CITY OF ALBUQUERQUE

**Re: Ceja Vista Subdivision (Phase 1) 98th St
Erosion and Sediment Control Plan
Engineer's Stamp Date 09/03/2019 (C12E003B8)**

Based upon the information provided in your submittal received 9/4/2019, the above referenced plan is approved to be included in the SWPPP and to apply for an ESC Permit/eNOI for grading and Work Order with the following conditions:

RECEIVING WATERS: UNNAMED POND	
CRITICAL HABITAT: CRITERION "A"; NO CRITICAL HABITATS WITHIN PROJECT AREA	
GPS LOCATION: 35.0235, -106.7402	
CEJA VISTA	
PROJECT TITLE	
ALBUQUERQUE, BERNALILLO COUNTY, NM	
CITY, COUNTY, STATE	
REV 09/03/2019	DATE
C. DURKIN	DRAWN BY

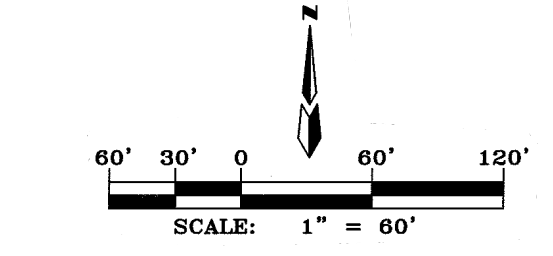
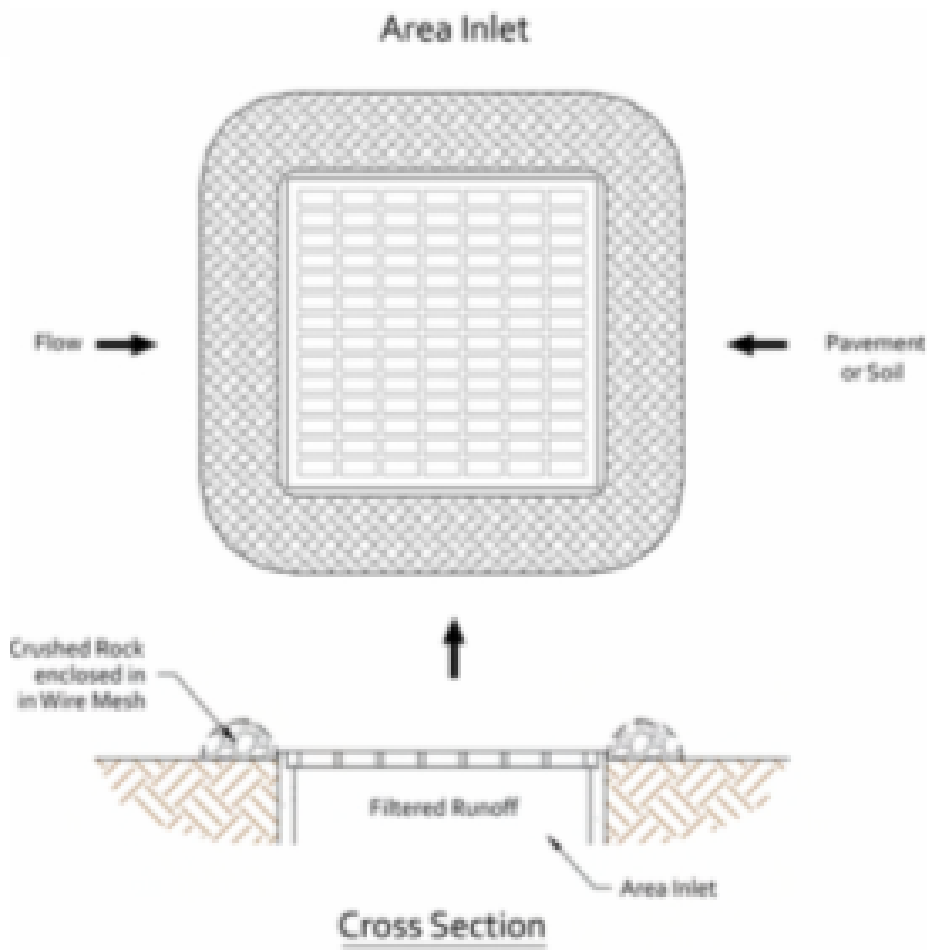
1. The construction entrance location is in the DOT/Dennis Chavez right of way and is subject to modification and approval by DOT. The entrance should be so configured so that construction traffic does not drive across dirt upon entering Denis Chavez from this site to include large radiuses at the intersection to accommodate construction traffic and channelization devices to keep construction traffic on the stabilized construction entrance.
2. The ponds swale should be the first items of construction.
3. The limits of work in the DOT right of way may be different than shown on this plan depending on the final DOT approved construction plans.
4. Track-out, if any, into Dennis Chaves roadway must be mitigated daily.
